Recommendation Report for Planning Permission for Works or Extension to a Dwelling

REF NO: AB/10/15/HH

LOCATION: 4 Orchard Place
Arundel

PROPOSAL: Retention of timber shed. This application affects the character & appearance of the Arundel Conservation Area.

**2124.1**

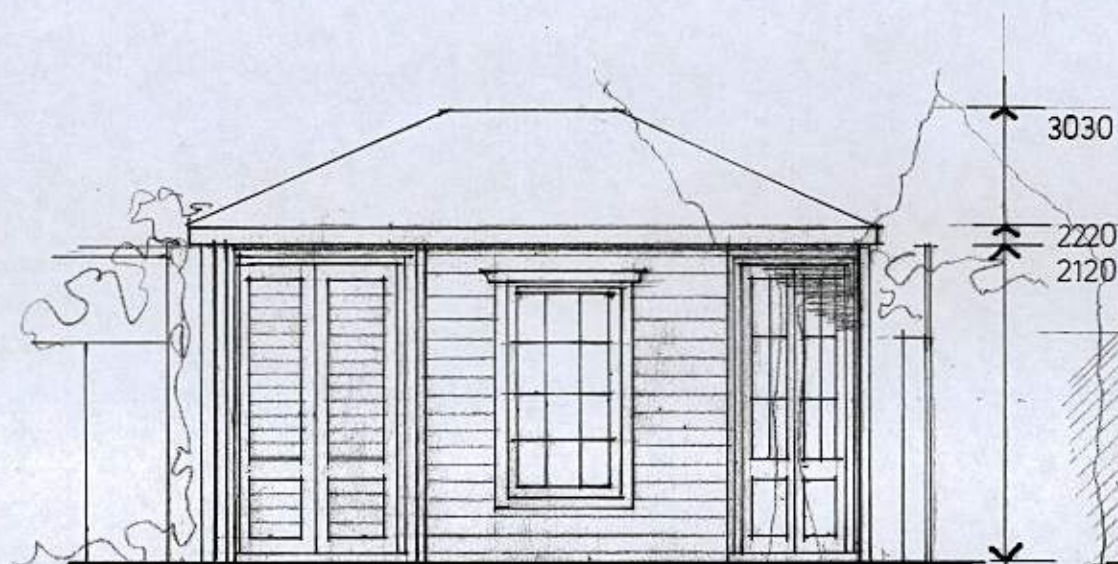
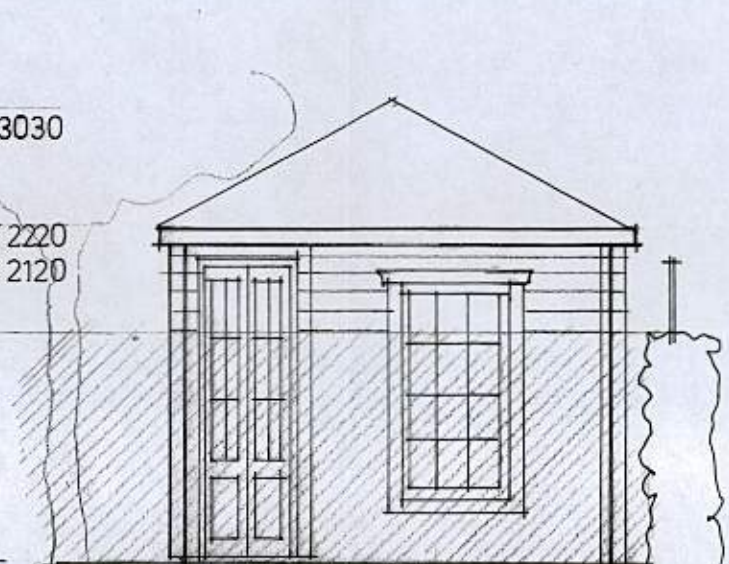
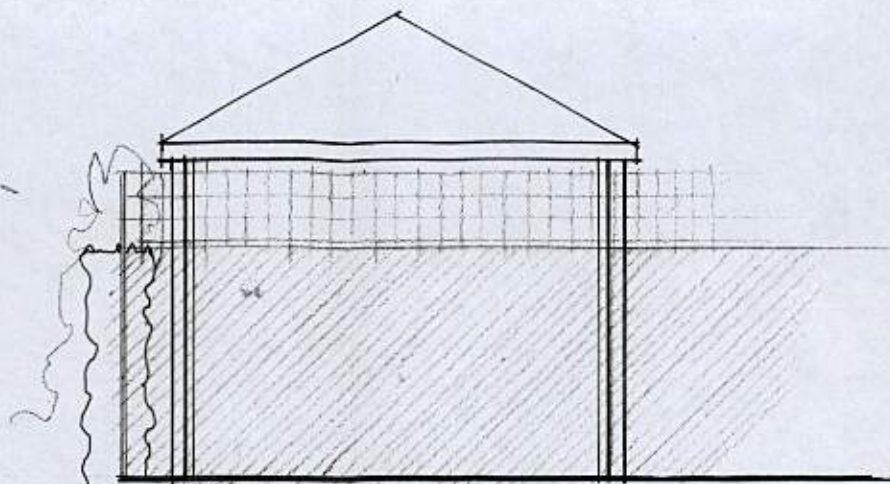
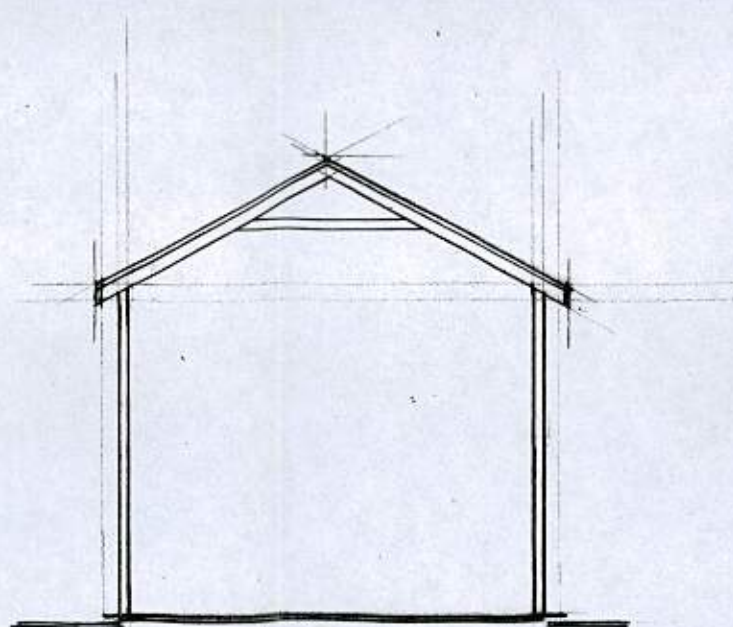
This planning application seeks permission for the erection of a 3 metre high structure in the rear of 4 Orchard Place.

The structure is located to the east of 4 Orchard Place at the end of the rear garden abutting the boundary. The structure is already in situ and replaced an existing 2.5 metre high shed located in the same position.

Whilst, the structure is not visible within the street scene - its design is not considered to preserve the character of the conservation area and as such the proposed shed is in conflict with Policy AREA2 of the Arun District Local Plan.

The structure is located upon the eastern boundary of the site. The structure is 0.5 metres higher than the shed which it replaced and as such it has an increased impact upon the residential amenity of 1 & 3 Parsons Hill.

The structure due to its height at 3 metres is deemed to cause unacceptable harm to the residential amenity of neighbouring properties as it give rise to unacceptable overbearing and overshadowing impacts. As such, the proposal is deemed to be in conflict with Policy GEN7 of the Arun District Local Plan.

- 1 The proposal will have an unacceptable prejudicial impact on the character and appearance of the area and will not preserve or enhance the character and appearance of the Conservation Area in conflict with policies GEN7 and AREA2 of the Arun District Local Plan.

- 2 The proposal would, by reason of its design, scale and position cause unacceptable harm to the residential amenities of adjoining properties in conflict with policy GEN7 (iv) of the Arun District Local Plan.
